RE: Clark Boundary Line Adjustment (BL-18-00008)

TO: Community Development Services
FROM: Taylor Gustafson, Environmental/Transportation Planner
DATE: June 18, 2018
SUBJECT: Clark BL-18-00008

CLARK PROPERTY

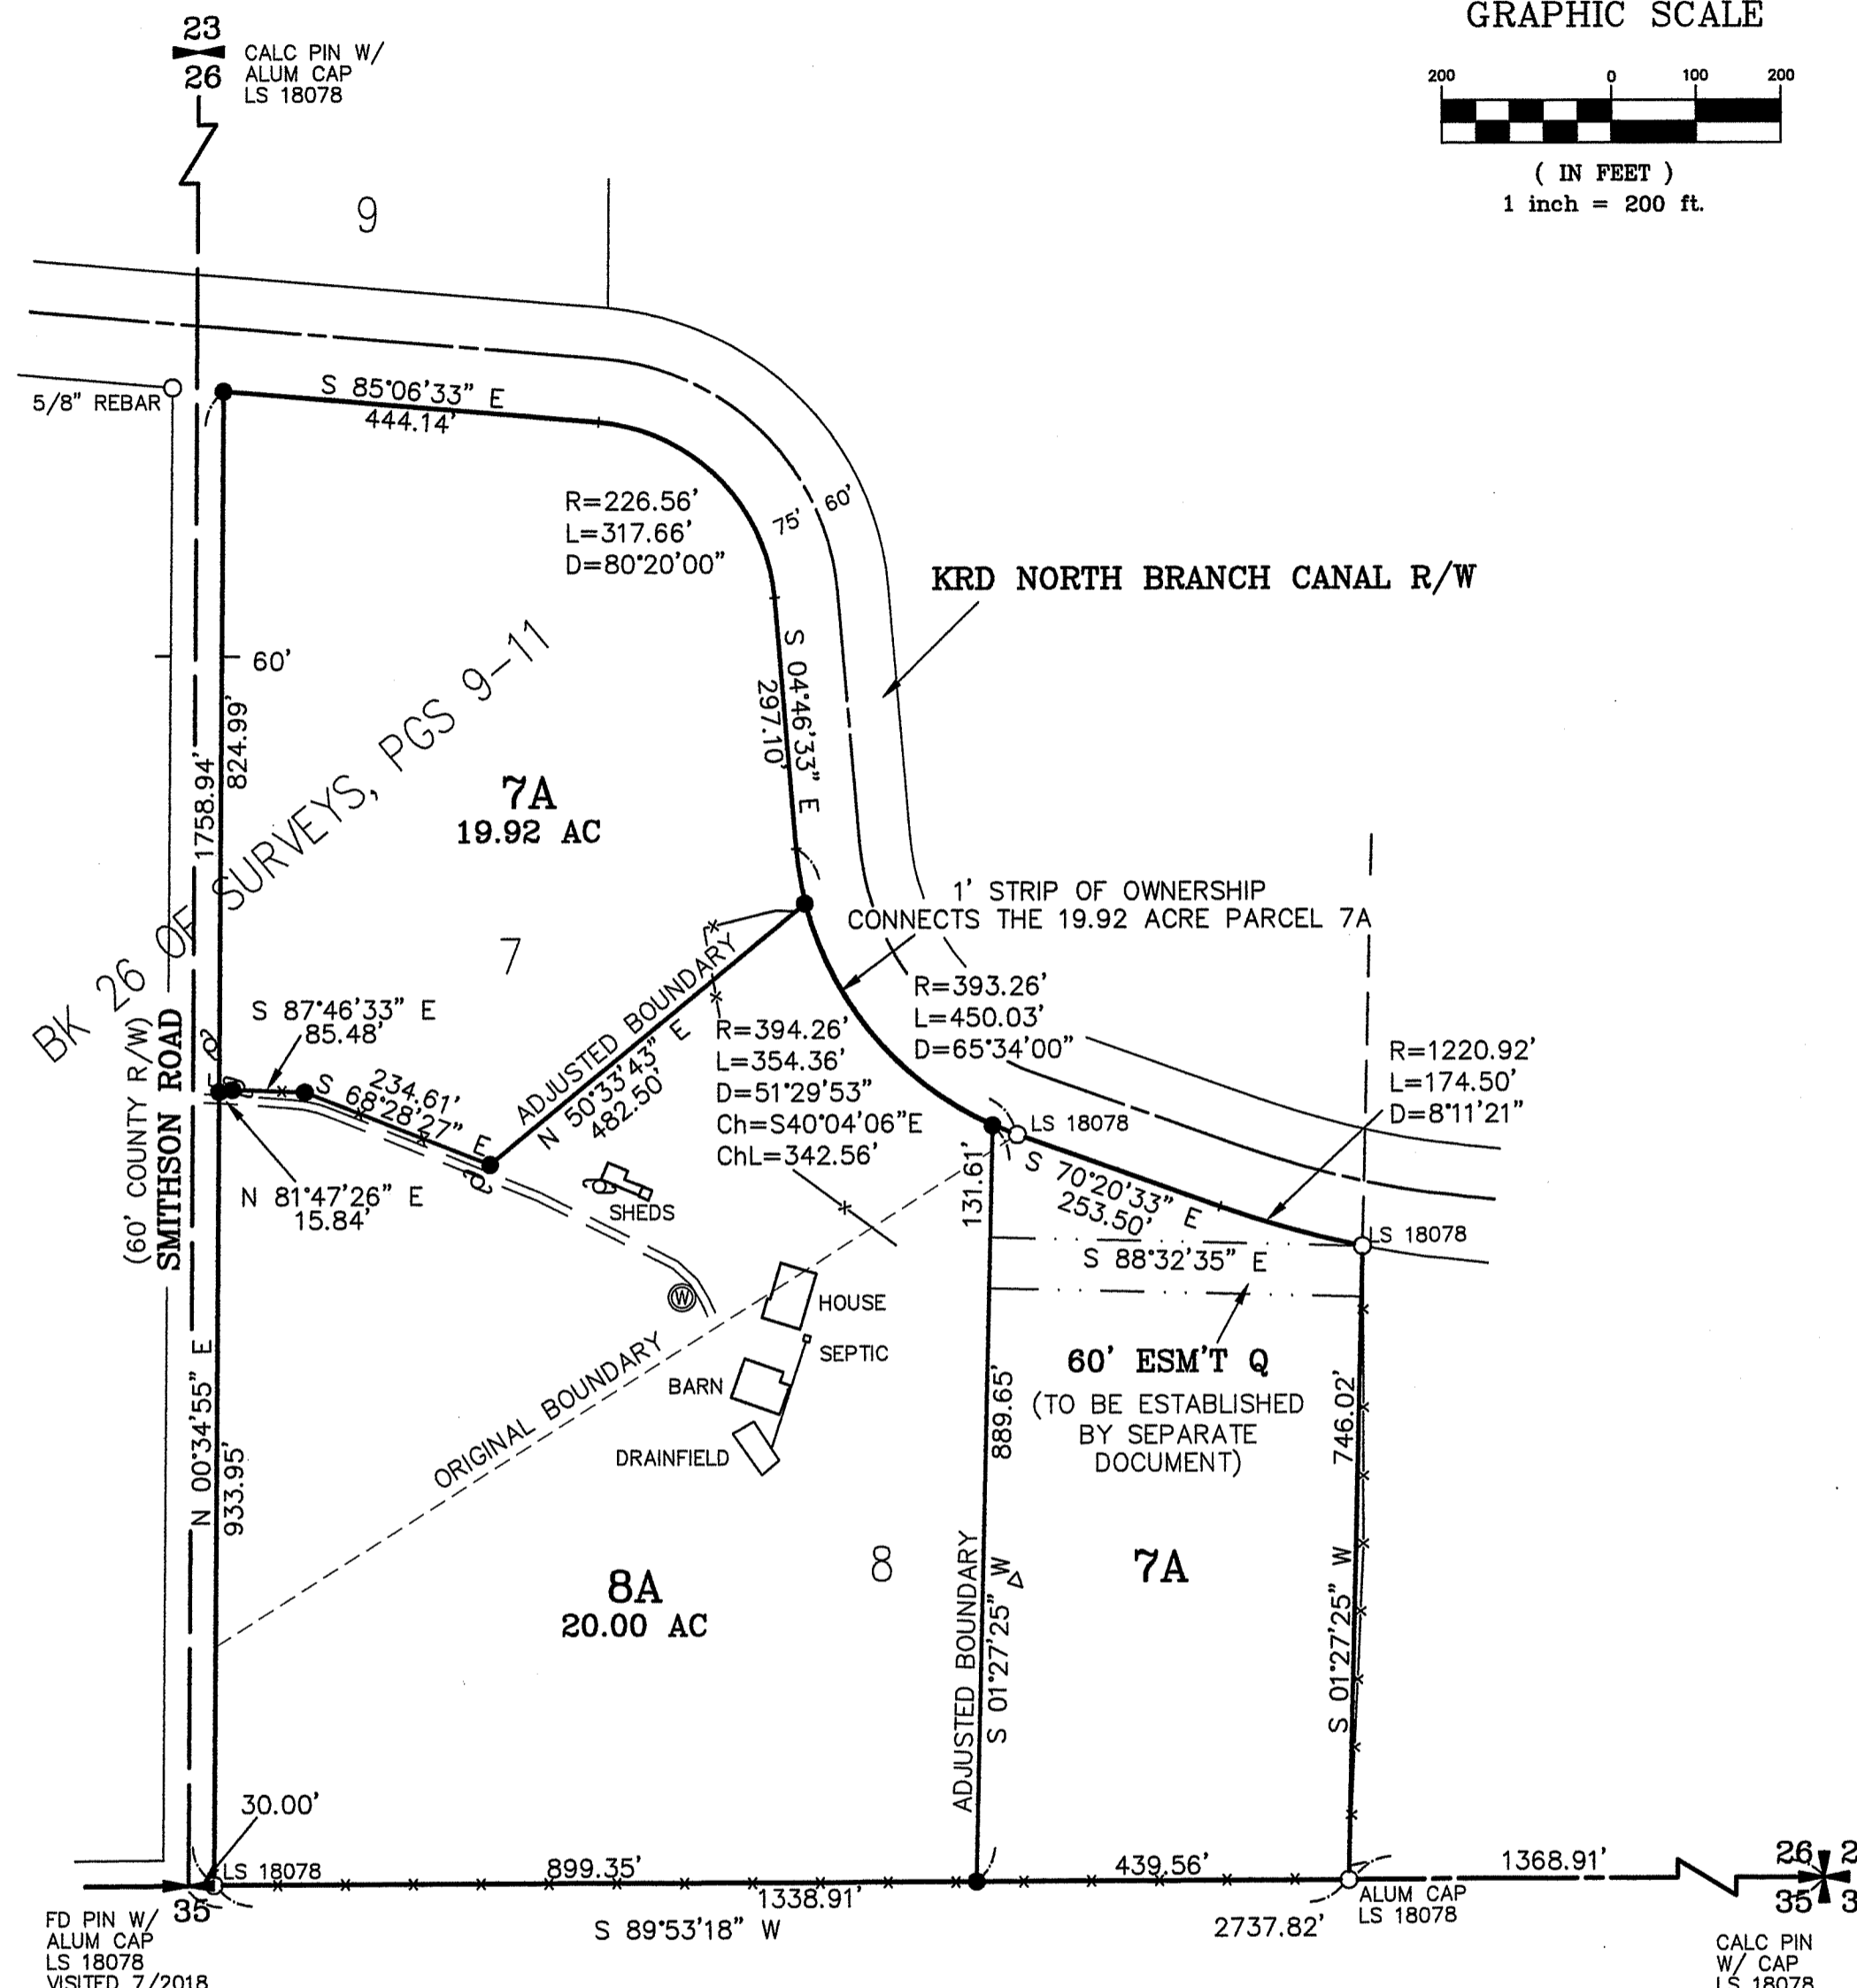
1. Provide sufficient access to the back half of lot 2. Proposed map shows only a 1' strip of land connecting the two sections.
2. Map shows County Right of Way as Church Road. Please relabel to Smithson Road.
